# City of Albuquerque

January 2, 2002

9001 Glendale

**RE: Building Permit vis-à-vis Lot 18, Block 16, Tract 1, Unit 3, North Albuquerque Acres**

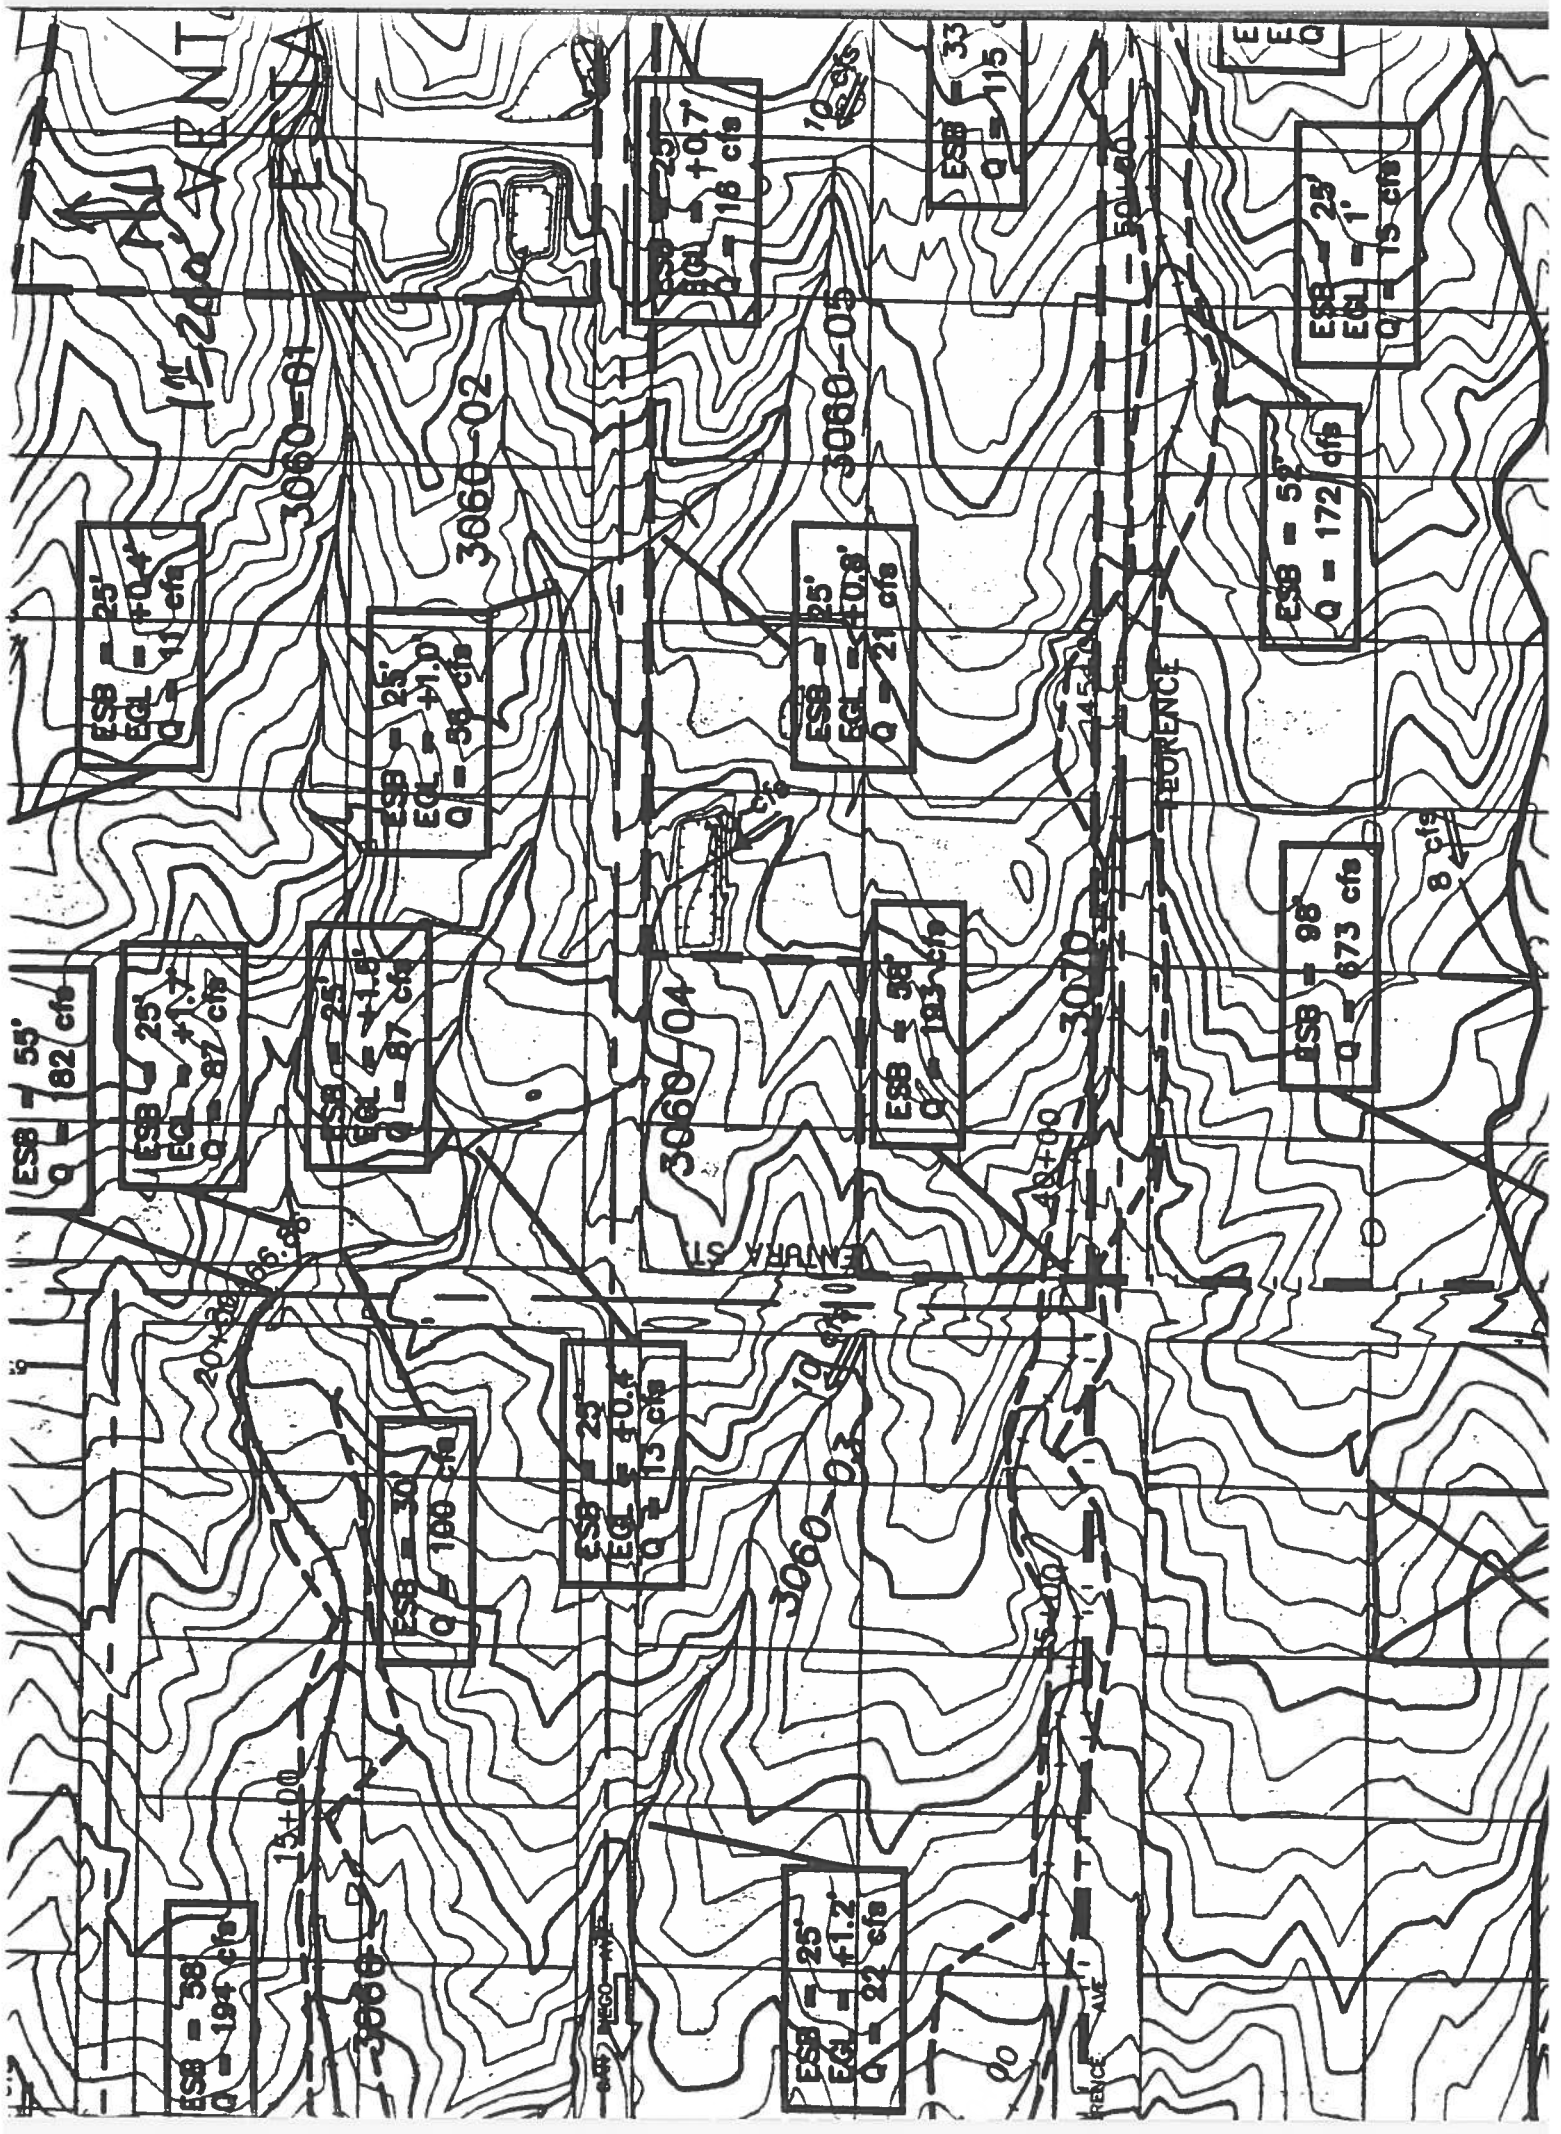
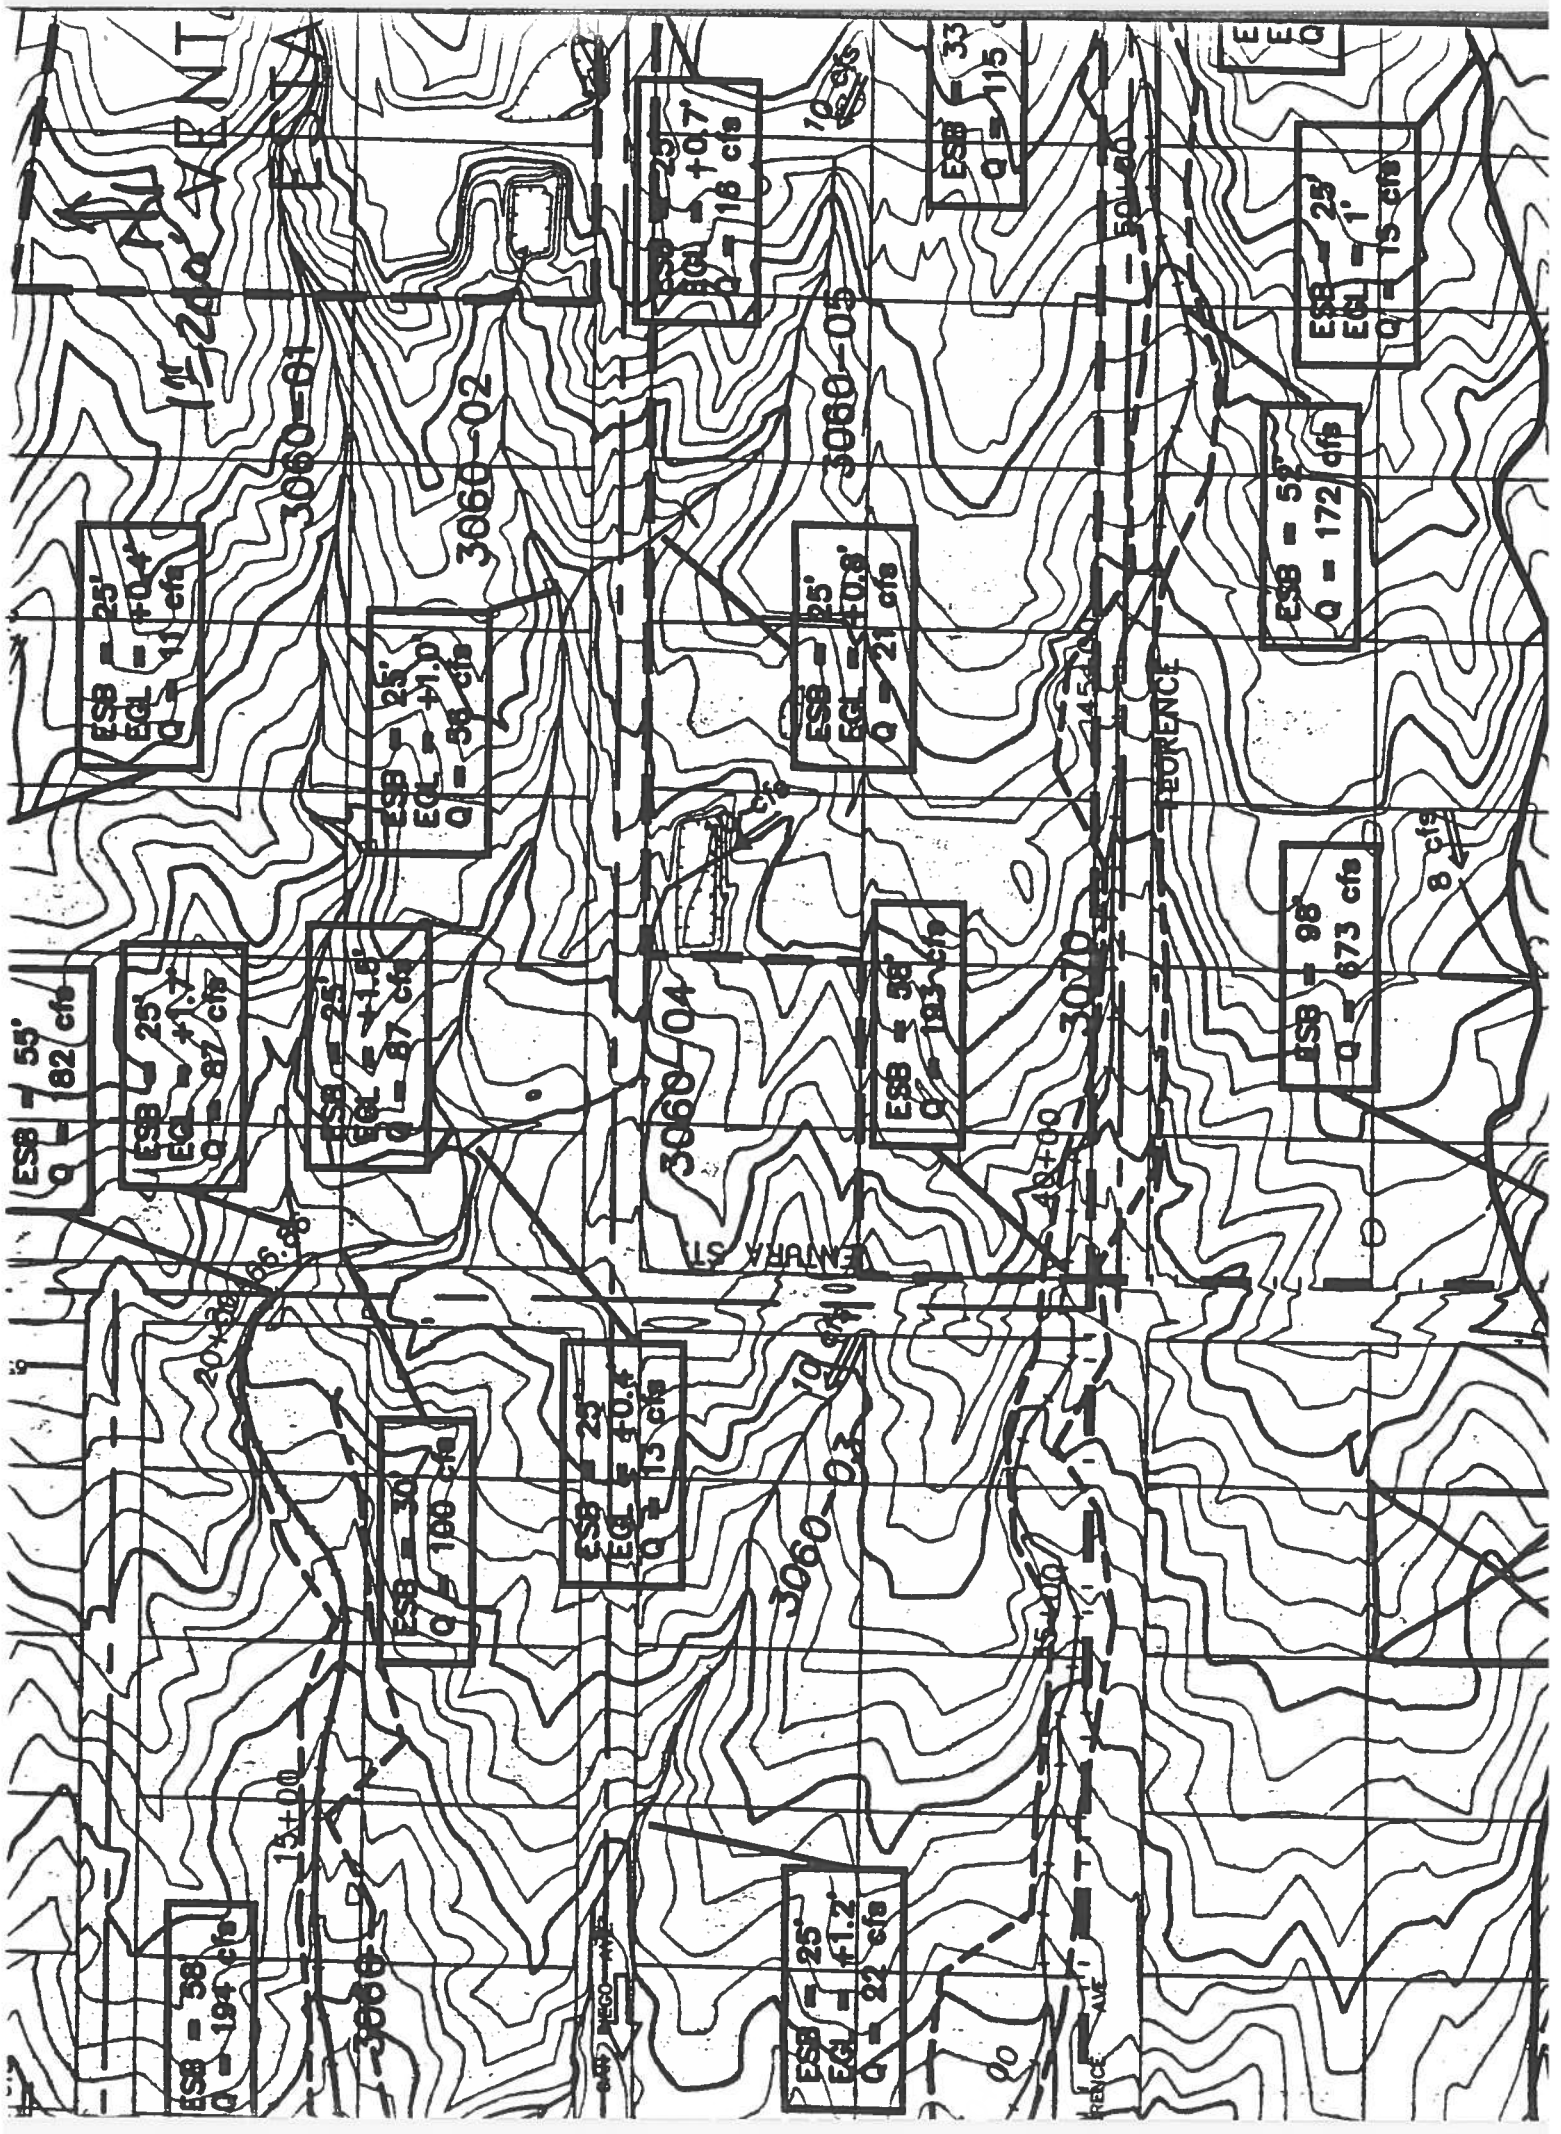
The 100-year floodplain is located adjacent to the south side of your lot on Glendale Avenue. The 100-year floodplain is that area impacted by the 100-year storm. The 100-year storm is precipitation within a six-hour period and resulting runoff that has a 1% chance of being equaled or exceeded in any given year.

The information above indicates that during the 100-year storm, the runoff within the floodplain adjacent to your lot is 673 cfs with a depth of 1 and 2 feet. Glendale Avenue, the road by which you access the property is clearly within the floodplain. Access to your property from Glendale Avenue during the 100-year storm would be extremely dangerous. The velocity and depth of the runoff could stall vehicles and carry them downstream. To mitigate the danger and protect against loss of life and property the City's Drainage Ordinance requires that an all-weather access road be provided to the property during the 100-year storm.

A building permit cannot be issued for this property unless a 100-year all weather access is constructed, or alternative ingress and egress is provided to the lot that does not cross the 100-year floodplain. Of course there would have to be legal access for the alternative access.
